REPORT UPDATE

REF NO: BR/218/09/

LOCATION: 6 Nelson Road
Bognor Regis
West Sussex

PROPOSAL: Erection of 1 no. 3 bed detached dwelling as an amendment to previously approved BR/2/09/

PROPOSED STREETSCENE ELEVATION

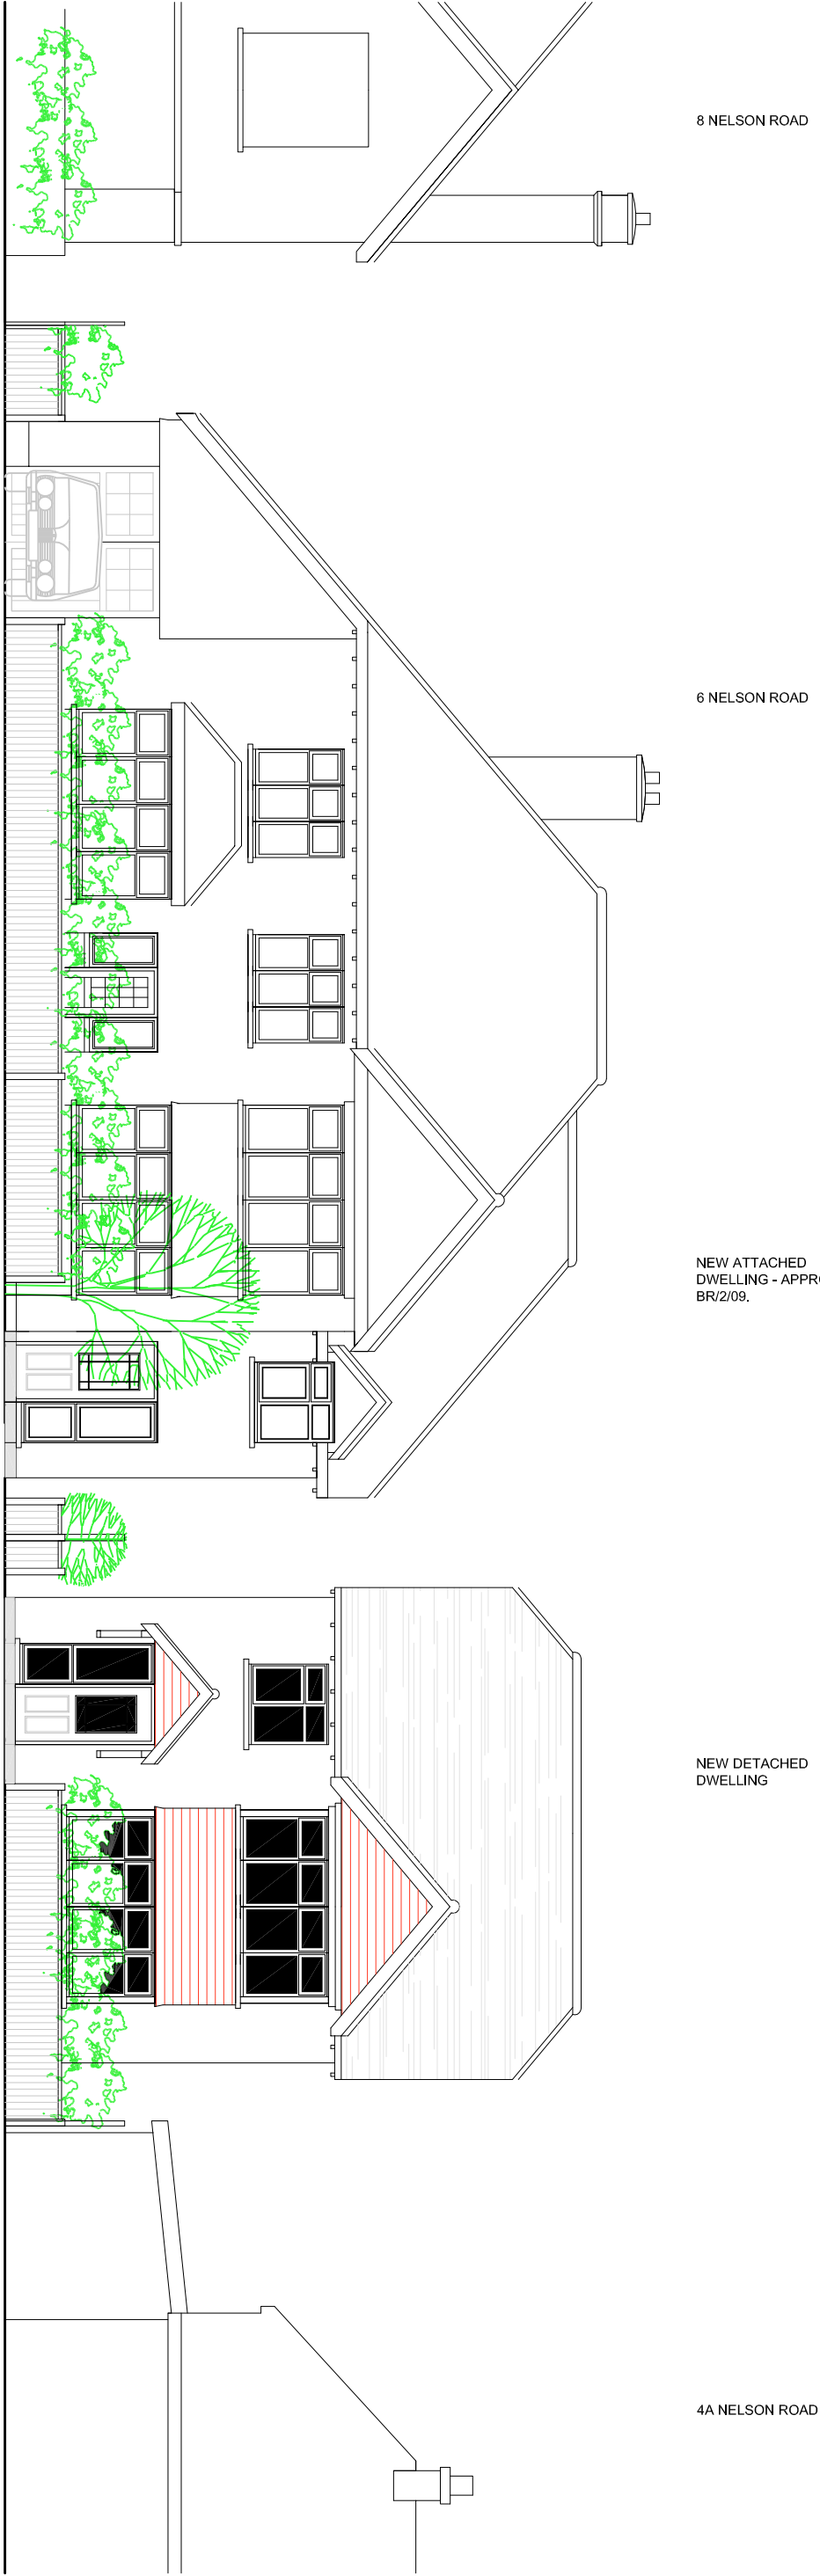
Objection from the Town Council on the grounds that the proposal represents an over development of the site and out of character with the street scene.

The site already benefits from permission to erect a dwelling.

PROPOSED ROOF PLAN

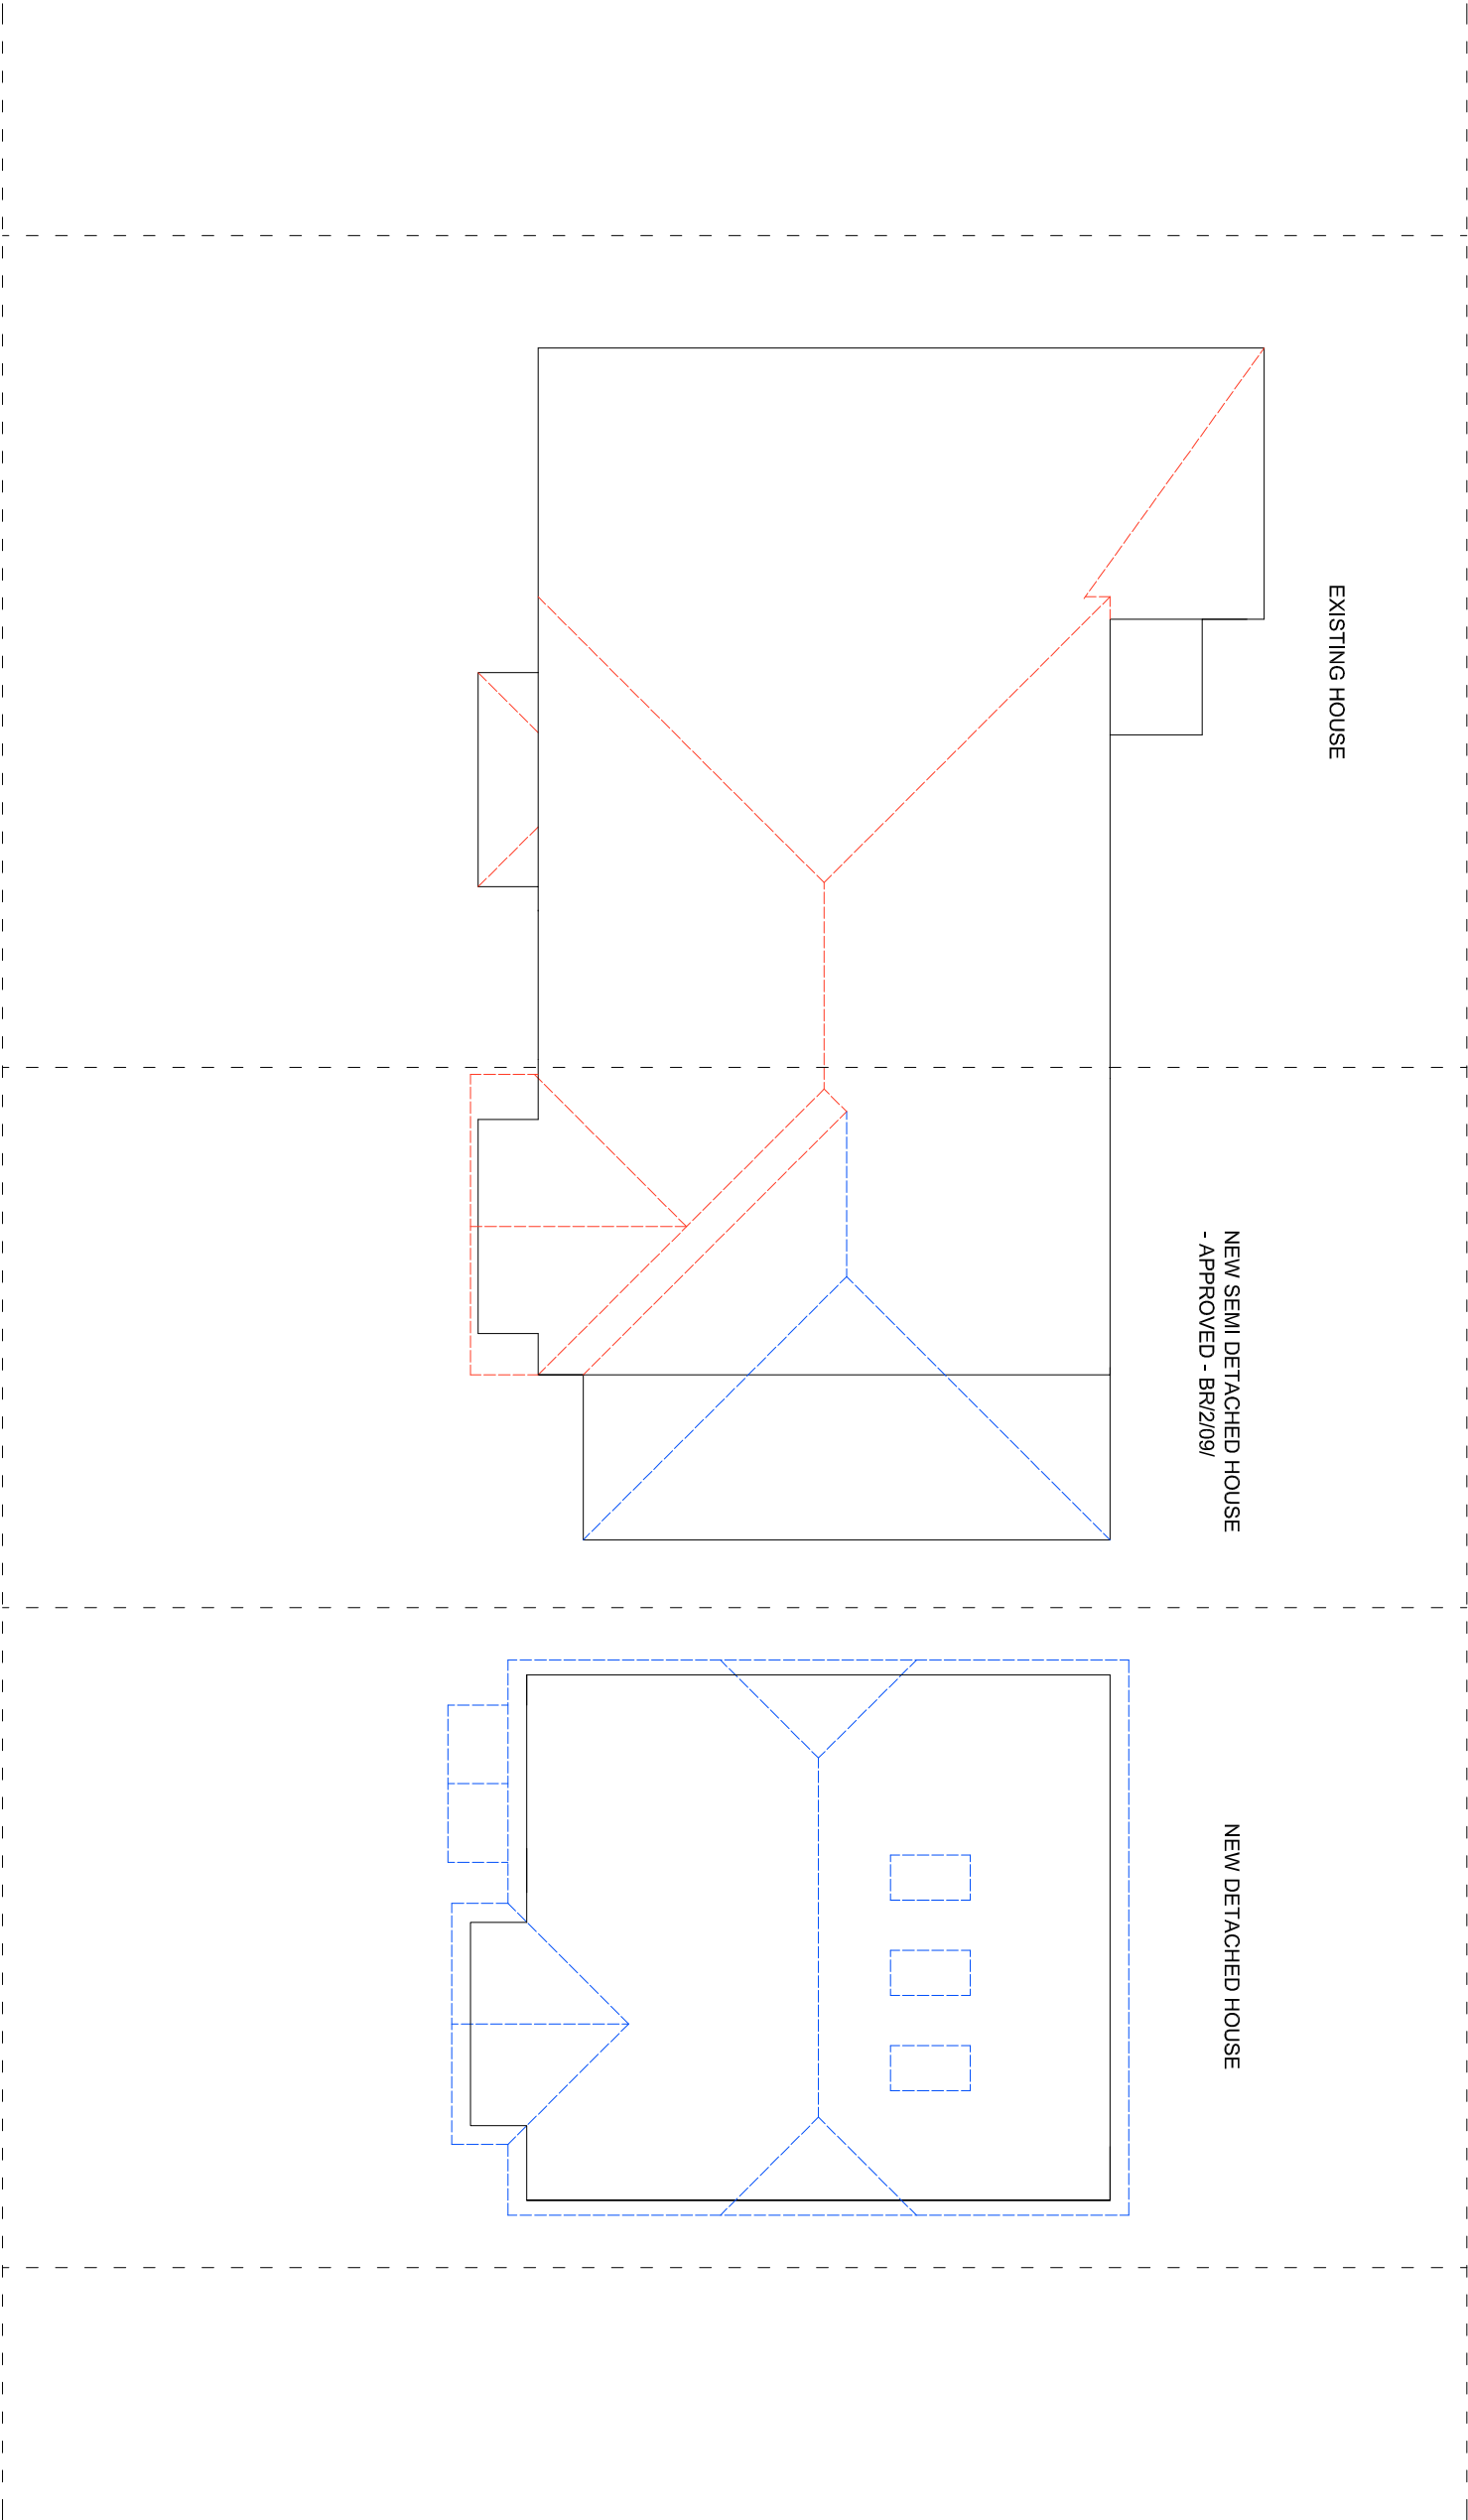
DESCRIPTION OF APPLICATION	Amendment to original permission (ref BR/2/09) comprising changing the profile of the roof to barn hips both ends rather than just to one end (west elevation facing number 6 Nelson Road).
SITE AREA	0.051 hectares
RESIDENTIAL DEVELOPMENT DEN	59 dwellings per hectare
TOPOGRAPHY	Predominantly flat
TREES	None of any significance affected by the proposed development.
BOUNDARY TREATMENT	One metre fencing to the front with mature hedging behind. Wall to side.
SITE CHARACTERISTICS	Large detached two storey house with a large side garden and small rear garden. One first floor side window.
CHARACTER OF LOCALITY	Neighbouring bungalow with no side windows. A lean to and garage on the boundary. A mix of styles and design of

The principle of a dwelling on the site has been approved under reference BR/218/09. What is up for consideration in this application is changing the profile of the roof facing 4a Nelson Road. Such a change will impact on the residential amenity levels of 4a and the character of the street. PPS1 & PPS3 emphasise the need to make efficient use of land for development but also advises that new housing is well integrated with and complement neighbouring buildings and the local area generally in terms of scale, density, layout and access. Regard is also needed towards protecting amenities and the existing use of lands and buildings.

PROPOSED DETACHED DWELLING ELEVATIONS

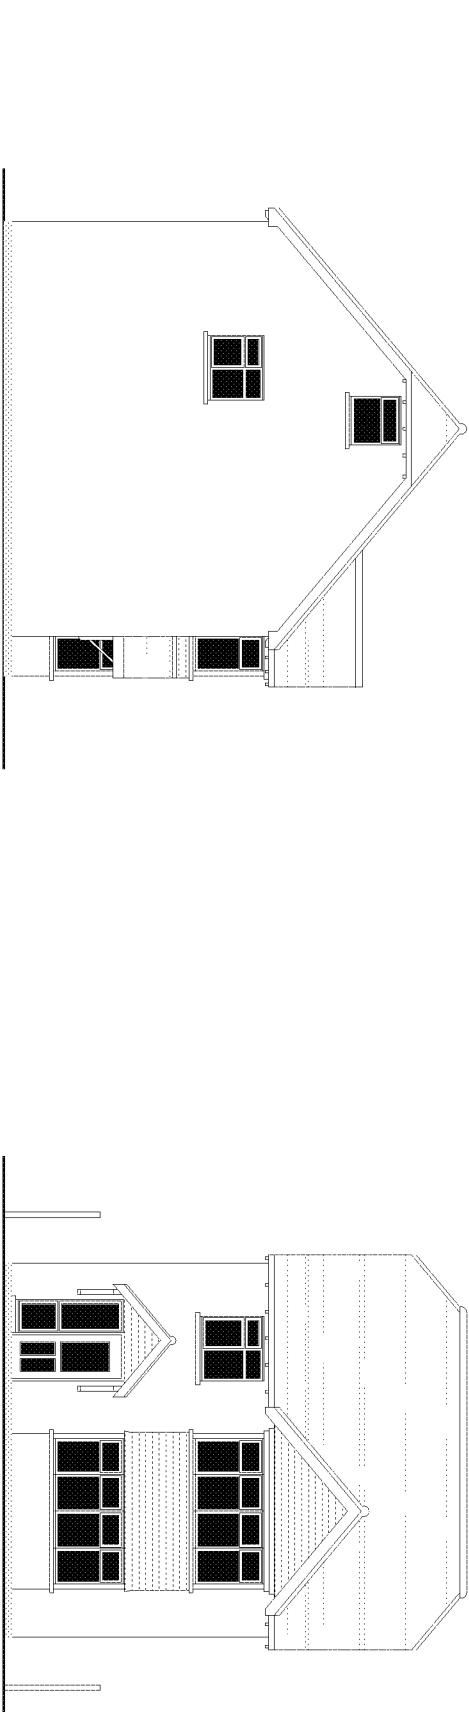
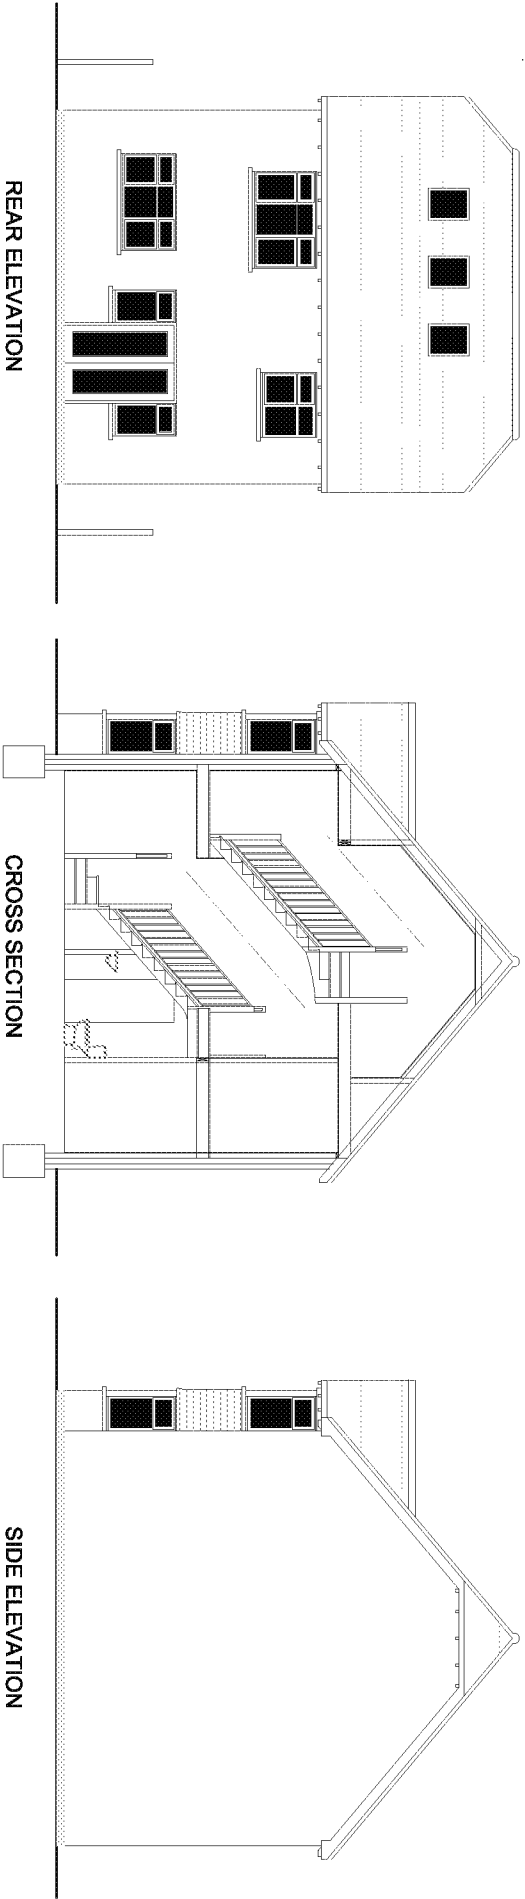
Changing the roof line to a barn end hip will result in the gable end wall facing number 4a increasing from 0.8m to 4.5m in height, an increase of 3.7m. This difference in profile and extra building mass is considered acceptable in amenity terms, given that this elevation is separated from the side elevation of 4a, where there are no side windows, by 3.4m.

Having a barn hip on this end will complement the proposed barn hip on the other end of the dwelling and thereby serve to preserve the character and appearance of the proposed dwelling and that of the wider locality. Given that there already exist a permission with a different roof profile the proposal is considered to represent an improvement to the visual amenities of the locality.
